From: Chantelle Bashford <Chantelle.Bashford@arun.gov.uk>
Sent: 10 November 2020 10:49
To: Planning.Responses <Planning.Responses@arun.gov.uk>
Subject: RE: Planning Consultation on: EP/125/20/PL

Application No: EP/125/20/PL

Site Address: 128 Sea Road East Preston BN16 1NN

Description of Works: Alteration & extensions to flat to create 2 No. one-bedroom self contained flats including loft conversion and dormers a(s approved EP/41/19/PL). This site is in CIL Zone 4 & is not CIL Liable as new flat.

PROPOSED

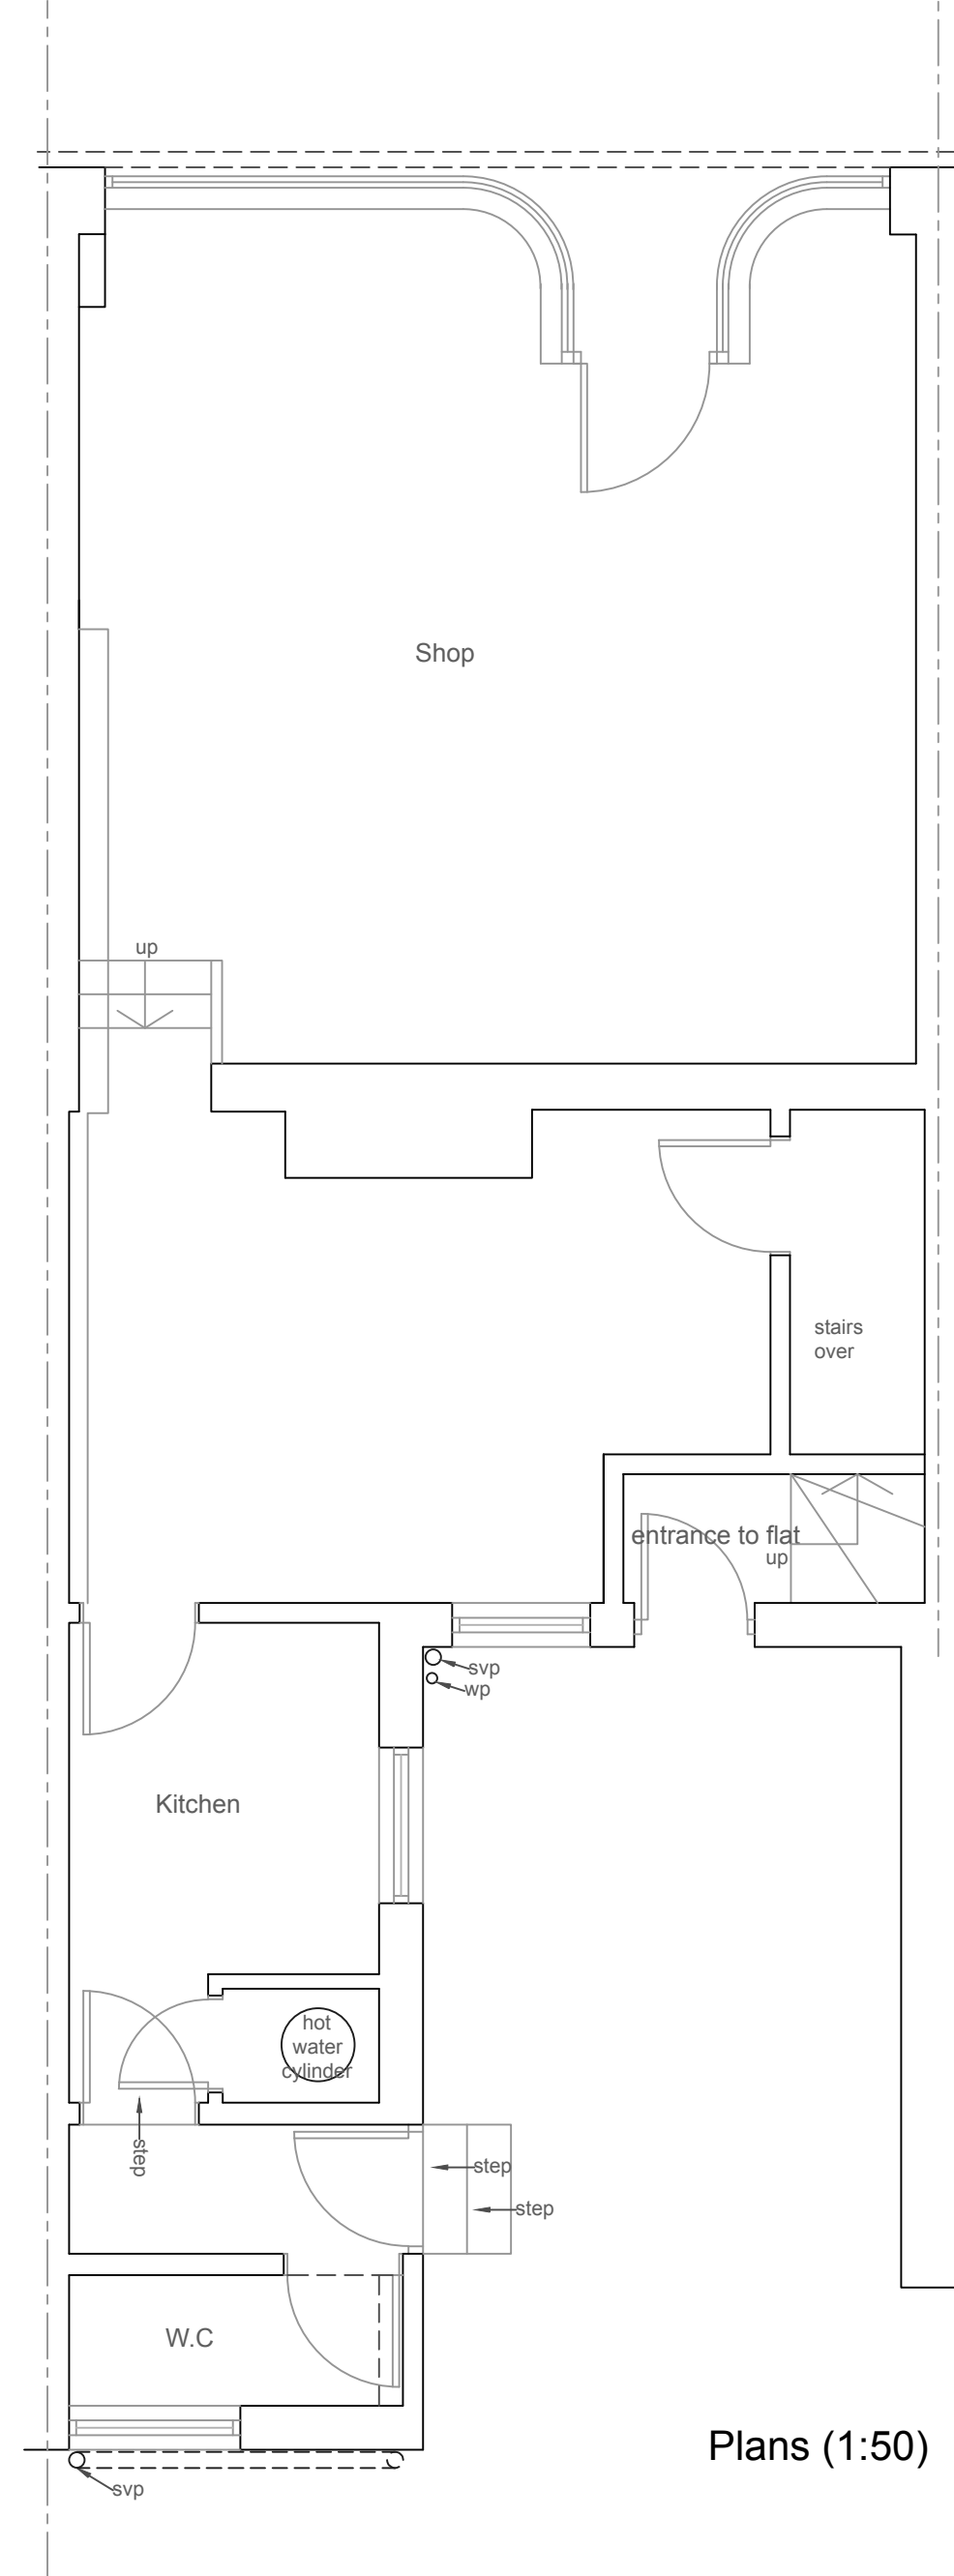
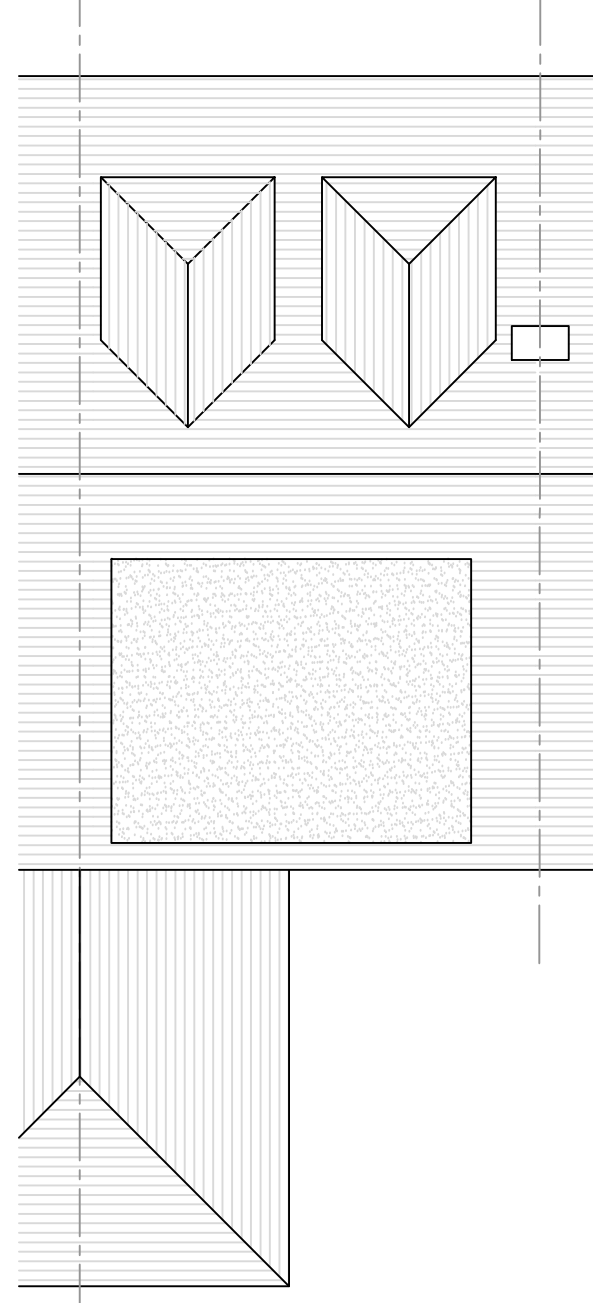
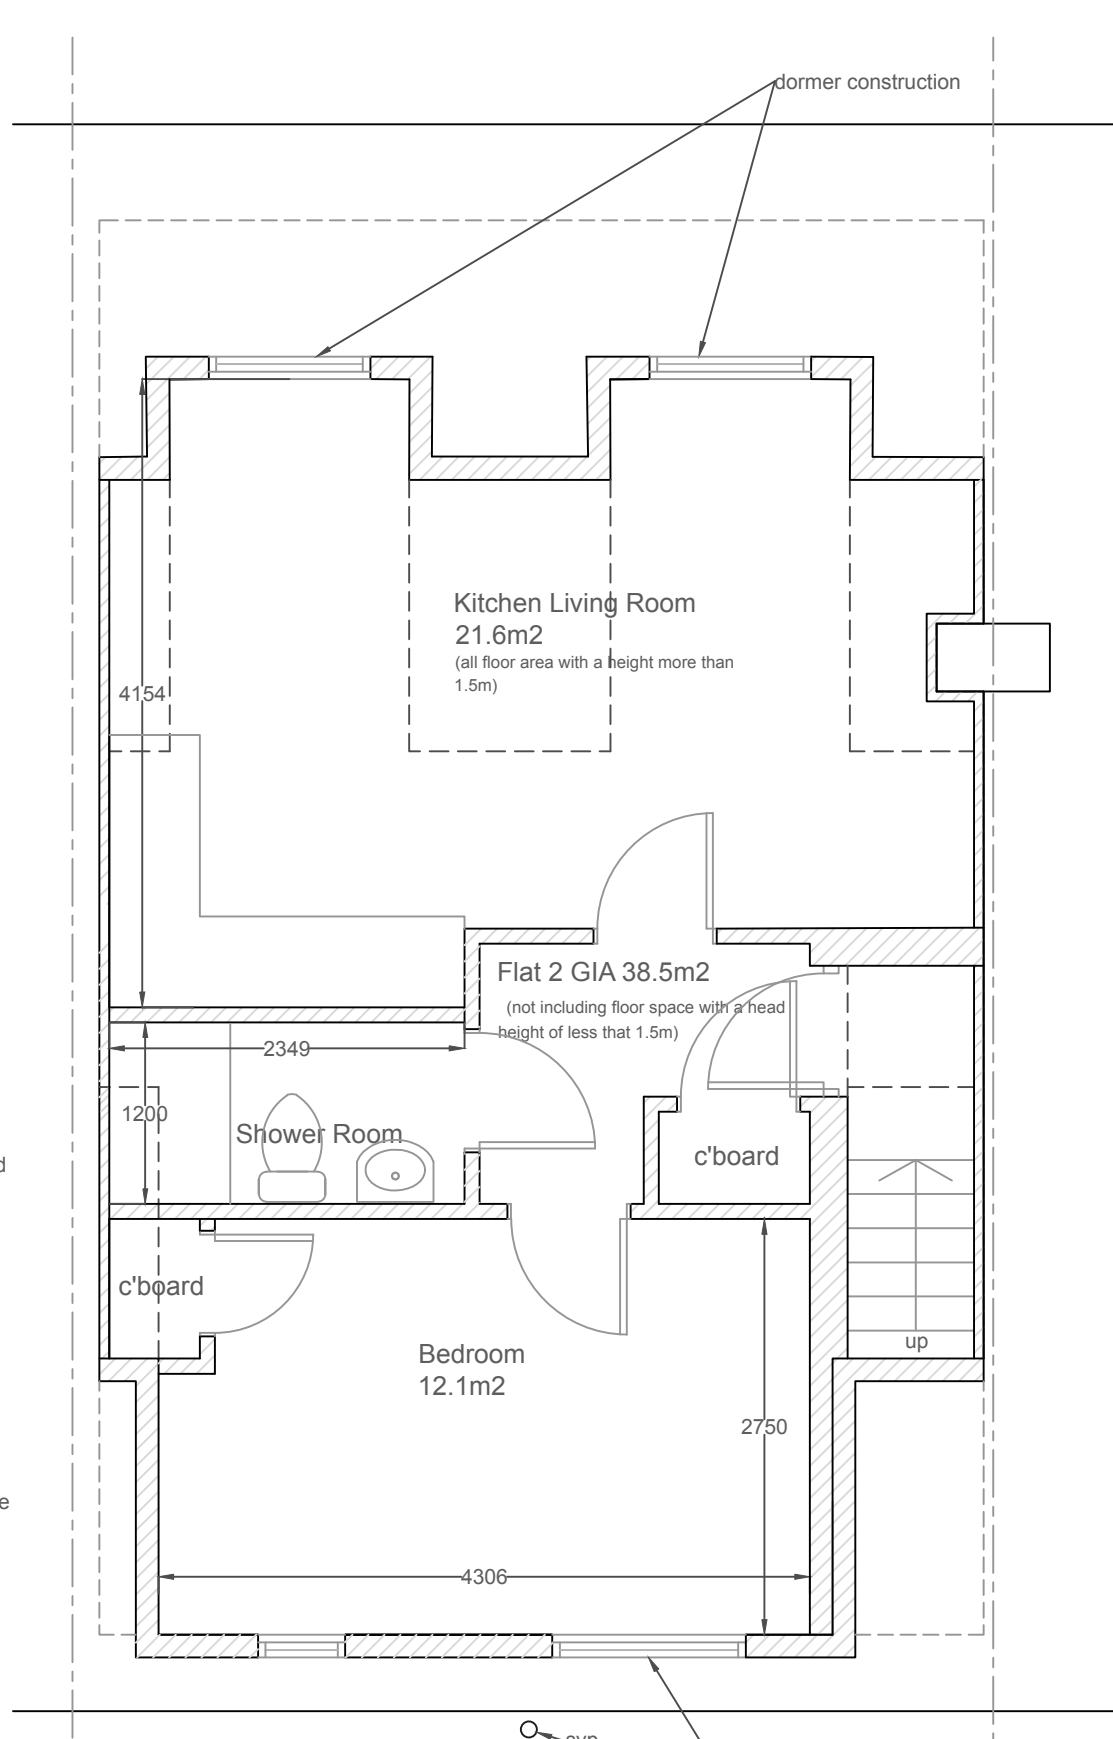
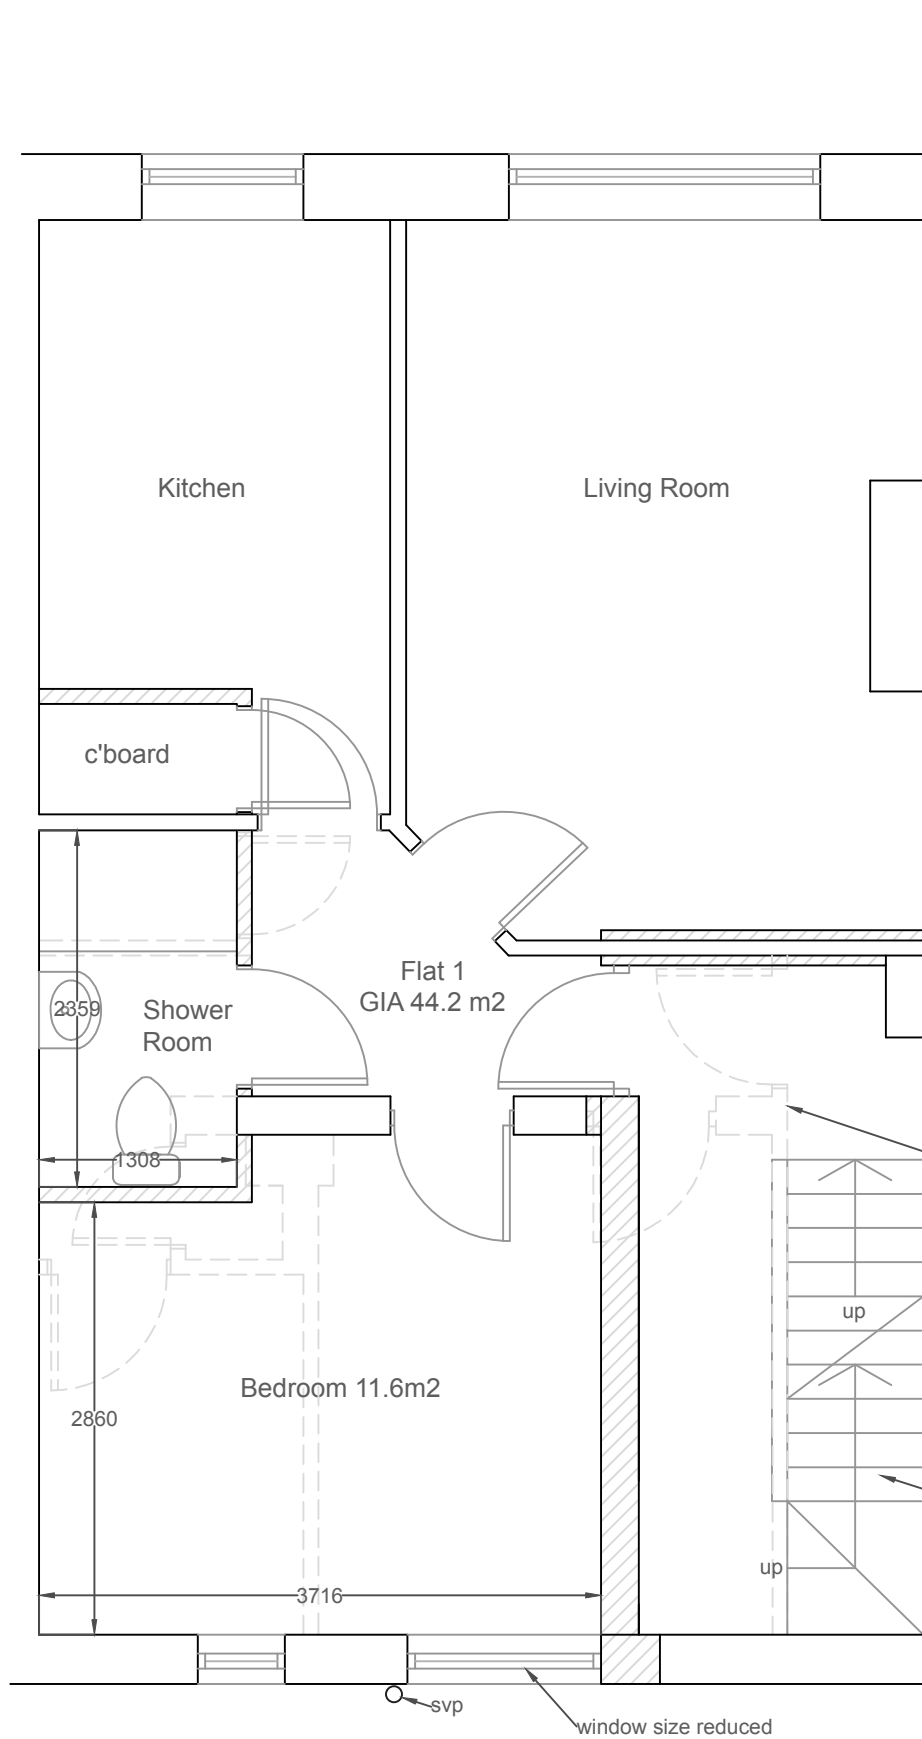
- Appropriate fire precaution facilities and equipment must be provided of such type, number and location as are considered necessary. Guidance on fire safety is contained in the LACORS guidance document – “Housing – Fire Safety, Guidance on fire safety precautions for certain types of existing housing”
- There should be adequate fire separation (usually 60 minutes) between the commercial unit on the ground floor and the residential flats above. If 60-minute fire separation cannot be fully achieved, interlinked detection will be required between the commercial unit and the residential flats above
- The commercial cupboard located under the staircase should afford 60-minutes fire resistance to protect the residential escape route

- The internal escape route should provide 30 minutes fire resistance, including the provision of 30-minute fire resisting and self-closing fire doors (FD30S) to each flat entrance
- As the building will be across 3 storeys, the fire detection will require upgrading to a mixed Grade A, LD2 and Grade D1, LD3 fire system.
Grade A, LD2 system:
 - Interlinked detection throughout the escape route
 - Interlinked heat detection to each flat
 - Interlinked detection to the commercial unit (if 60-minute fire separation cannot be fully achieved)
- Grade D1, LD3 system:
 - Non-interlinked mains-wired smoke alarms with integral tamper-proof battery back-up to each flat
- Fire blankets should be provided to all kitchen areas
- Emergency lighting may be required to the escape route due to the lack of effective borrowed light

- The floor to ceiling height must be at least 2.1 metres over at least 50% of the floor area when measured at a height of 1.5metres from the floor and provide sufficient useable space

- Kitchens should have adequate mechanical ventilation
- Mechanical extraction should be provided to all bathrooms/shower rooms/en suites
